Case Officer: Harry Chalk
Reference: FG/6/22/T
Location: 19 Oval Waye, Ferring, BN12 5RA
Proposal: 1no. stone pine tree - Crown lift to 4m over both driveways and road
Reasons given: To maintain reasonable clearance over driveway and road

Plan 1

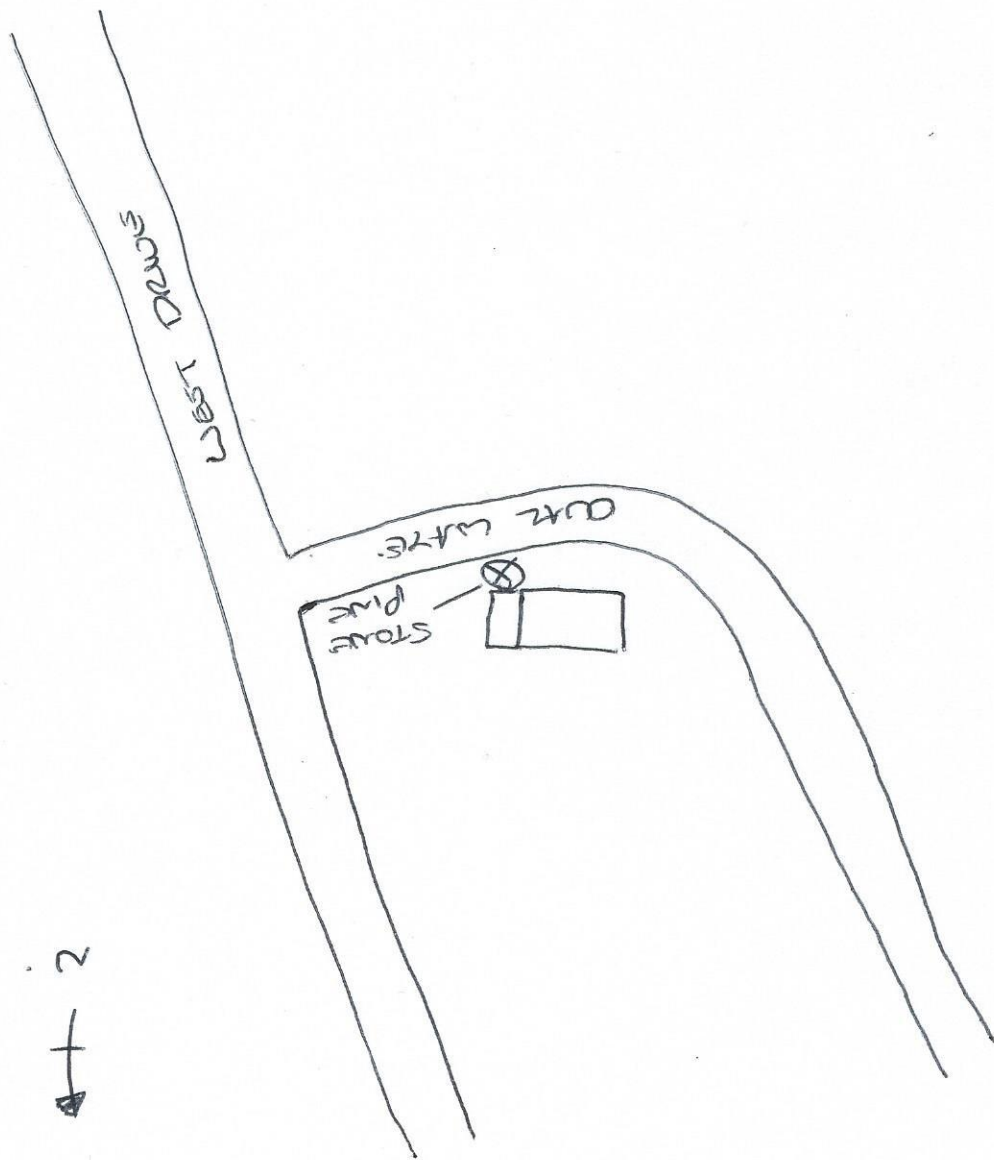
- Outwardly and from roadside this tree appears to be in a fine physiological state and assumed to be so in the absence of any evidence provided to the contrary.
- It has multiple established low limbs and presents a broad crown. It has high growth potential and dominates boundary at the front of properties. Visually impressive within the street scene and a challenge to maintain in harmony with surroundings.

- Careful pruning of selected branches is necessary to abate nuisance and so justified on arboricultural grounds.
- Minimal loss of visual amenity will occur if the work is undertaken to a high standard and at an appropriate time of year.

- I recommend **CONSENT** is granted subject to the following condition:

Part a) Where whole branches are to be removed and final cuts made close to the trunk or branch union they are to be made as shown in Figure 2 of BS3998:2010

Part b) Where branches are to be shortened back the final cuts are to be made at the correct angle shown in BS3998:2010 and adjacent to a live bud or lateral.
